Development Facilitation Team (DFT) – Review Comments

Project No: PR-2022-006568

Application For: SD-2023-00147- REHEARING OF PRELIMINARY PLAT (DHO)

Project Name: 9200 Wilshire Subdivision

CITY OF ALBUQUERQUE
PUBLIC WORKS DEPARTMENT
ENGINEERING DEVELOPMENT GROUP
WILSHIRE PLACE SUBDIVISION
GRADING AND DRAINAGE
GRADING PLAN

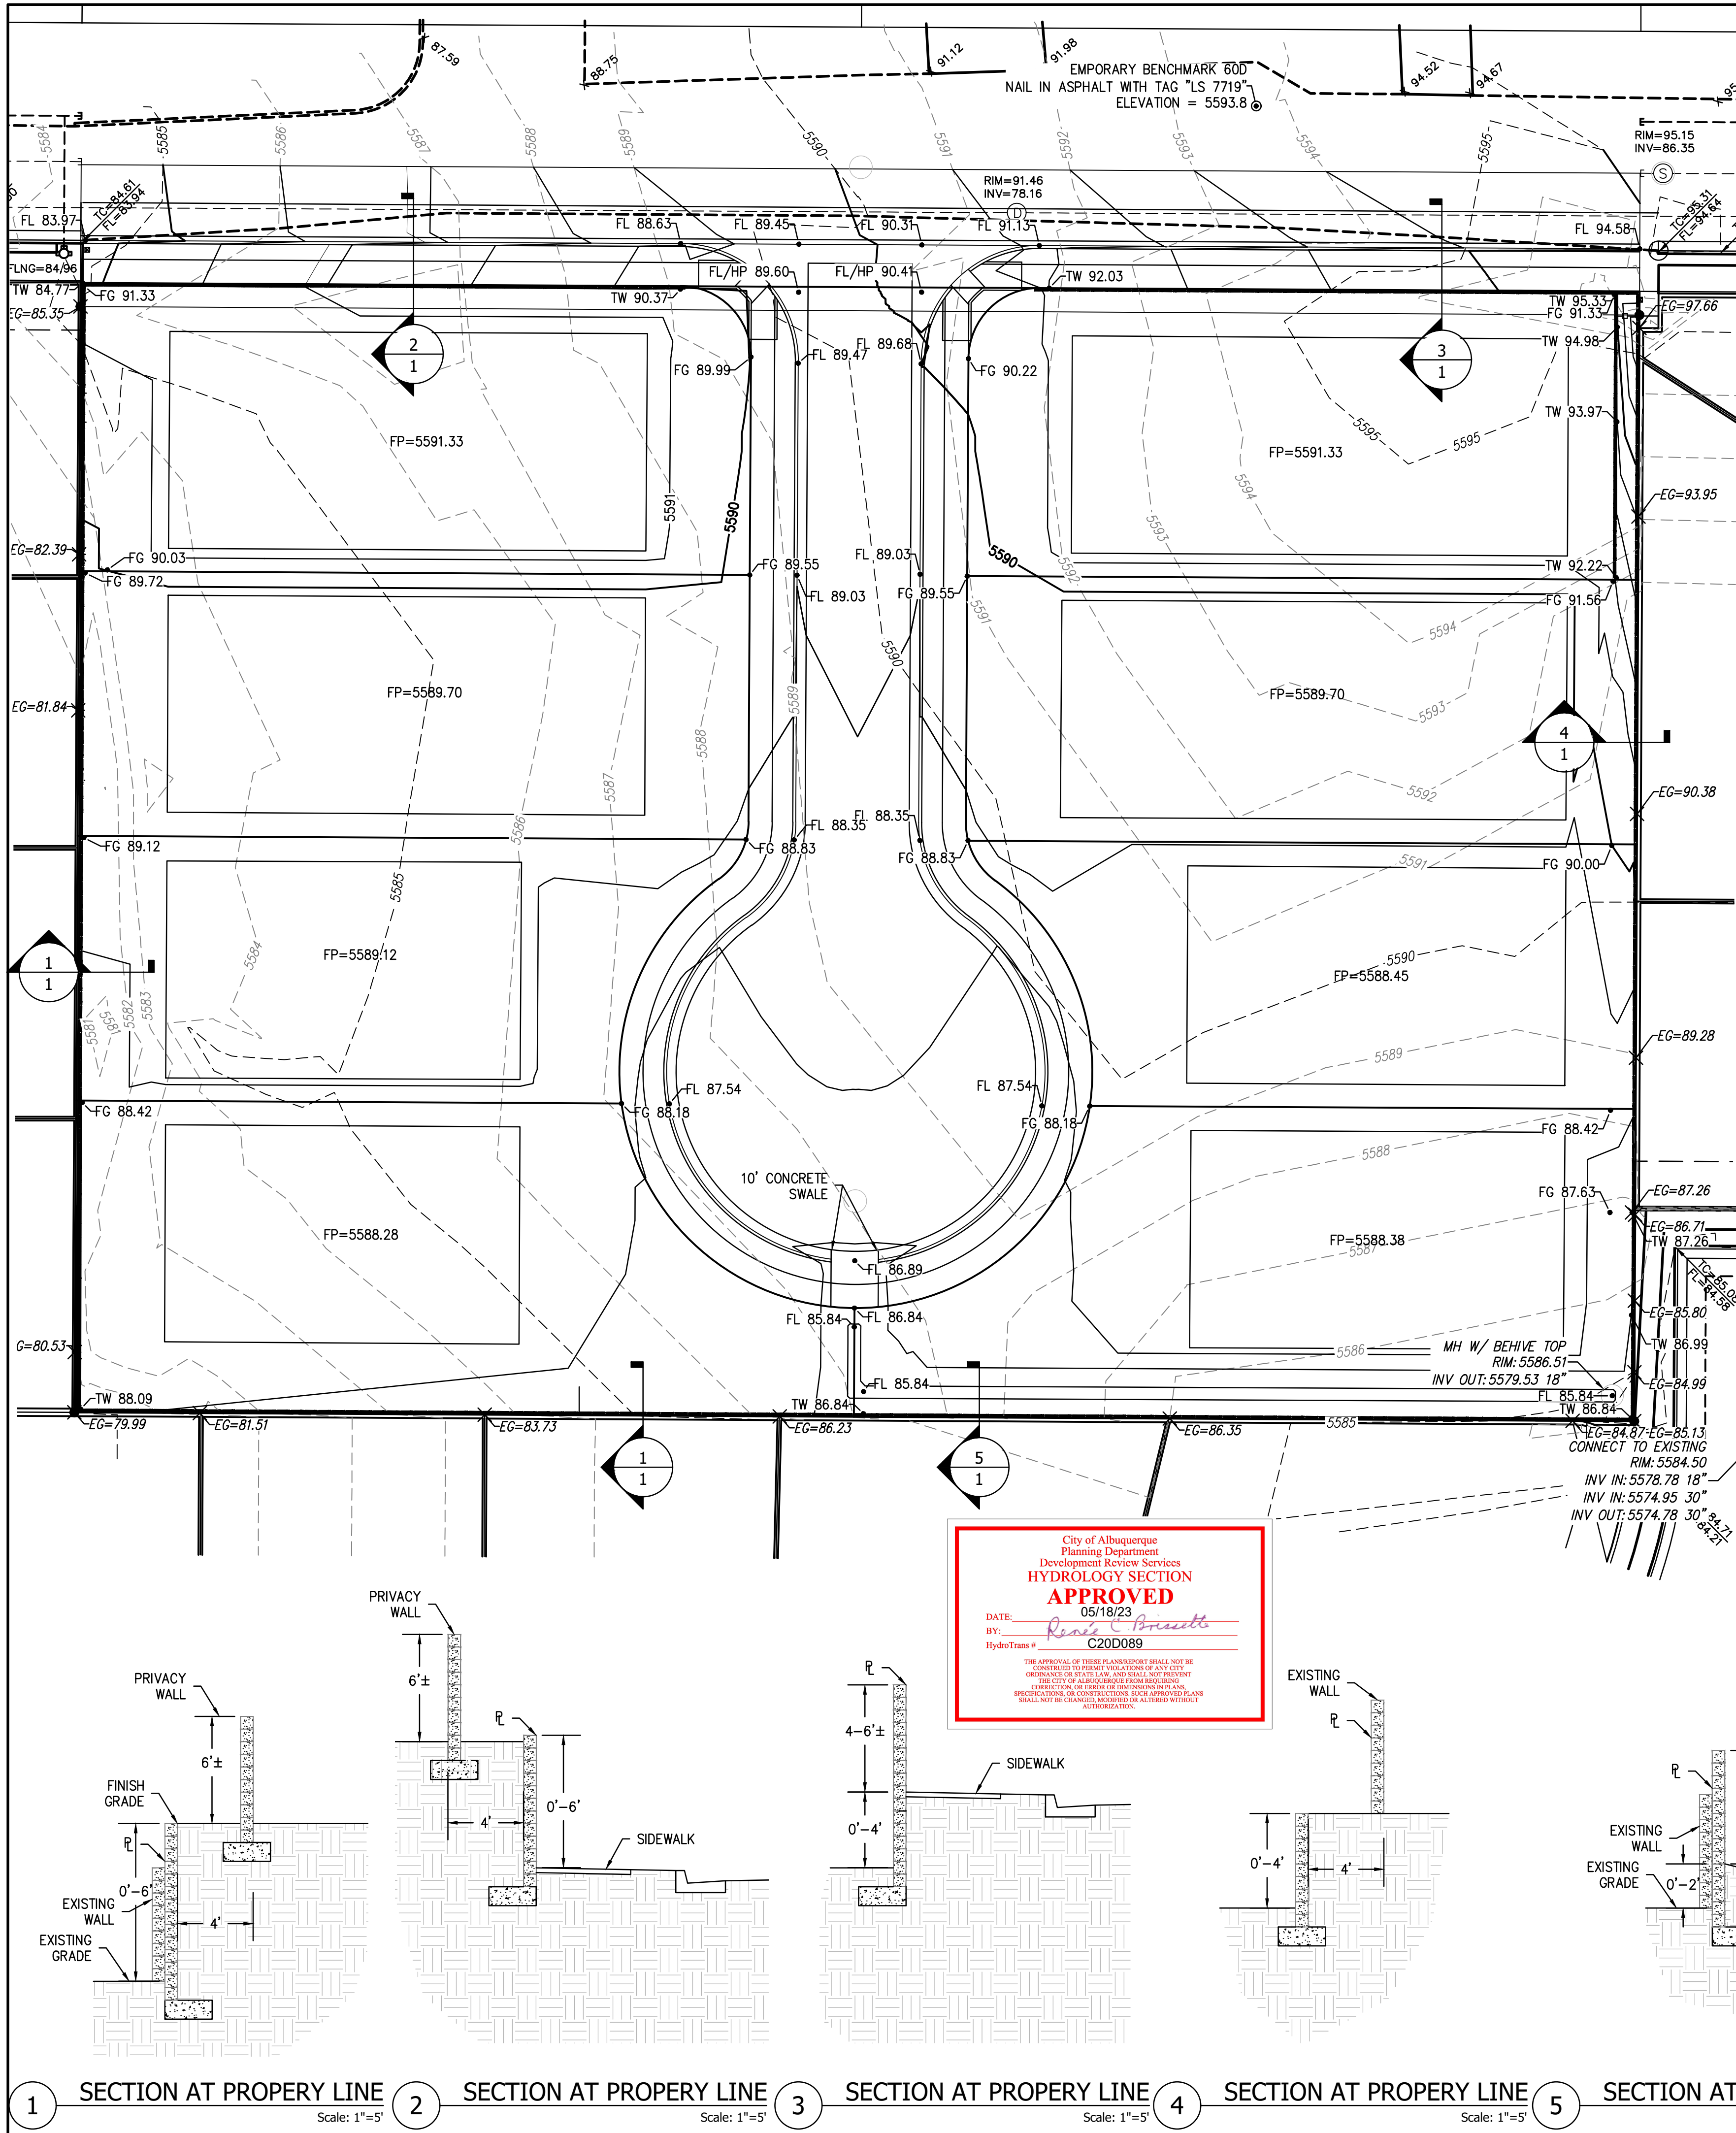
- Hydrology has an approved Grading & Drainage Plan (C20D089) with engineer's stamp date of 05/01/2023 and the supplemental submittal dated 01/18/24.
- A retaining wall higher than 3 feet must be approved by the City Engineer (IDO 14-16-5-7(F)(1)(a)) and higher than 6 feet shall be terraced (IDO 14-16-5-7(F)(2)(b)).
- Comment – Please send the updated Grading & Drainage Plan with all corrections associated with this project during the Preliminary Plat approval for Grading Permit and Work Order approval.

- The subdivision grading plan must comply with IDO 5-4(J)(1)(b) below.

1 SECTION AT PROPERTY LINE Scale: 1"=5'
 2 SECTION AT PROPERTY LINE Scale: 1"=5'
 3 SECTION AT PROPERTY LINE Scale: 1"=5'
 4 SECTION AT PROPERTY LINE Scale: 1"=5'
 5 SECTION AT PROPERTY LINE Scale: 1"=5'
 6 SECTION AT PROPERTY LINE Scale: 1"=5'

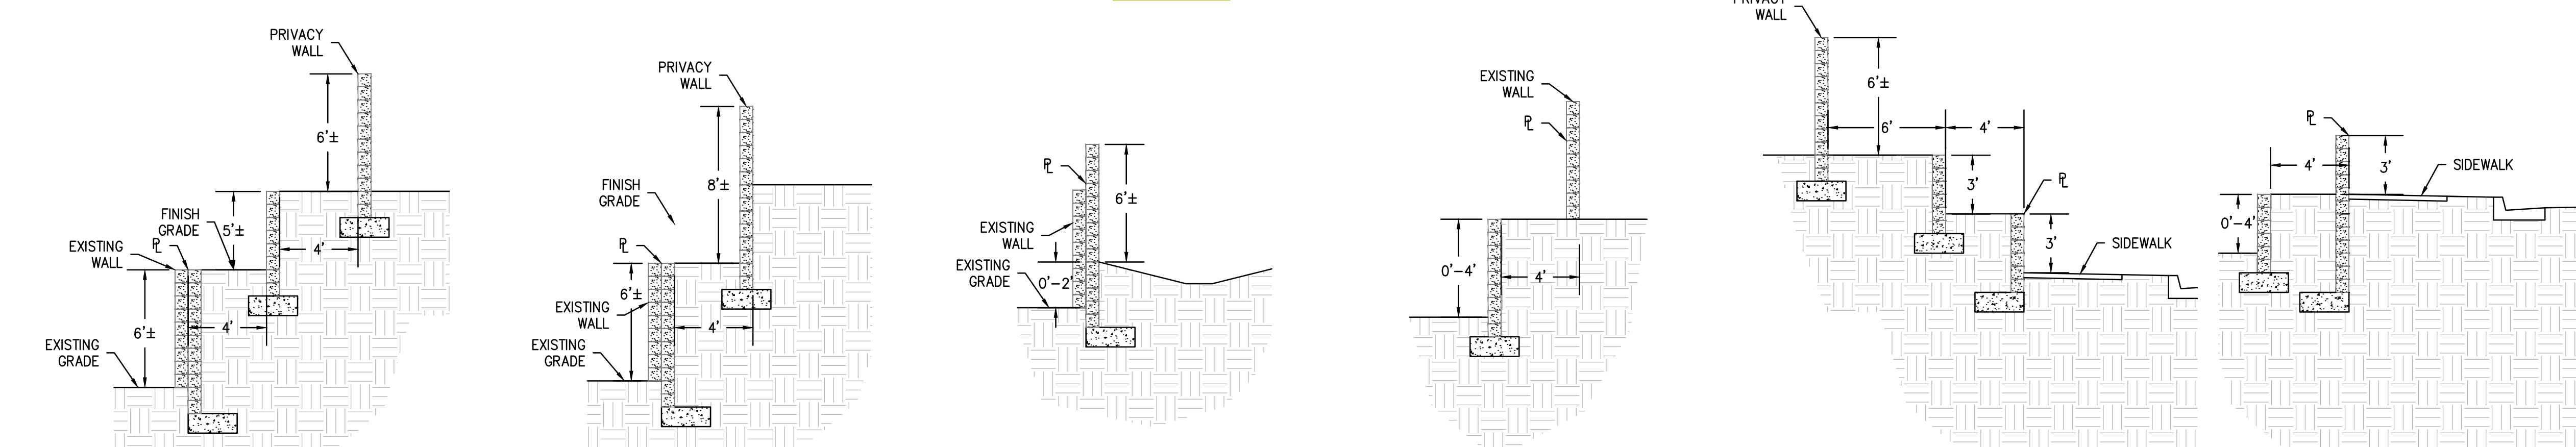
2. Upper retaining wall outlined in drawing #2 is showing 8 ft plus or minus...but must be terraced if over 6 feet. Need to clarify what is going to be done.

A new submittal was received on 2/2/24. The retaining walls greater than 6 feet along the western property line have been changed so that there is a second terrace. The final retaining wall heights are not listed and they need to be listed. Some of the figures remain confusing. Please clean up this exhibit for clear review of retaining wall heights AND show the height of a joint retaining/privacy wall that is retaining wall. All walls must be compliant with IDO 5-7(F) below. (Areas of concern are highlighted in blue circles below.)

- New wall sections are shown at the bottom of the wall height diagram. **Please make the following corrections:**

Wall Section 1: The wall height for the retaining wall should be shown separately from the existing wall. The retaining wall needs to show a limit of 6 feet (do not use plus or minus; you can use minus only). For the second terrace, the retaining wall needs to show a limit of 6 feet (you can use 5-6 feet, but not 5 feet plus or minus). The Privacy Wall should show a limit of 6 feet (anything over 6 feet as the third wall would create 20-feet of total wall height in an area that is not topographically dramatic). A privacy wall of 6 feet atop 12 feet grade change is sufficient.

Wall Section 2: The wall height for the retaining wall should be shown separately from the existing wall. The retaining wall needs to show a limit of 6 feet (do not use plus or minus; you can use minus only). The second wall, shown only as Privacy Wall, needs to show the height of the portion that is a retaining wall (limited to 6 feet). Overall wall height cannot be higher than 8 feet (remove plus or minus; you can use minus only).

Wall Section 6: Show height of retaining wall.
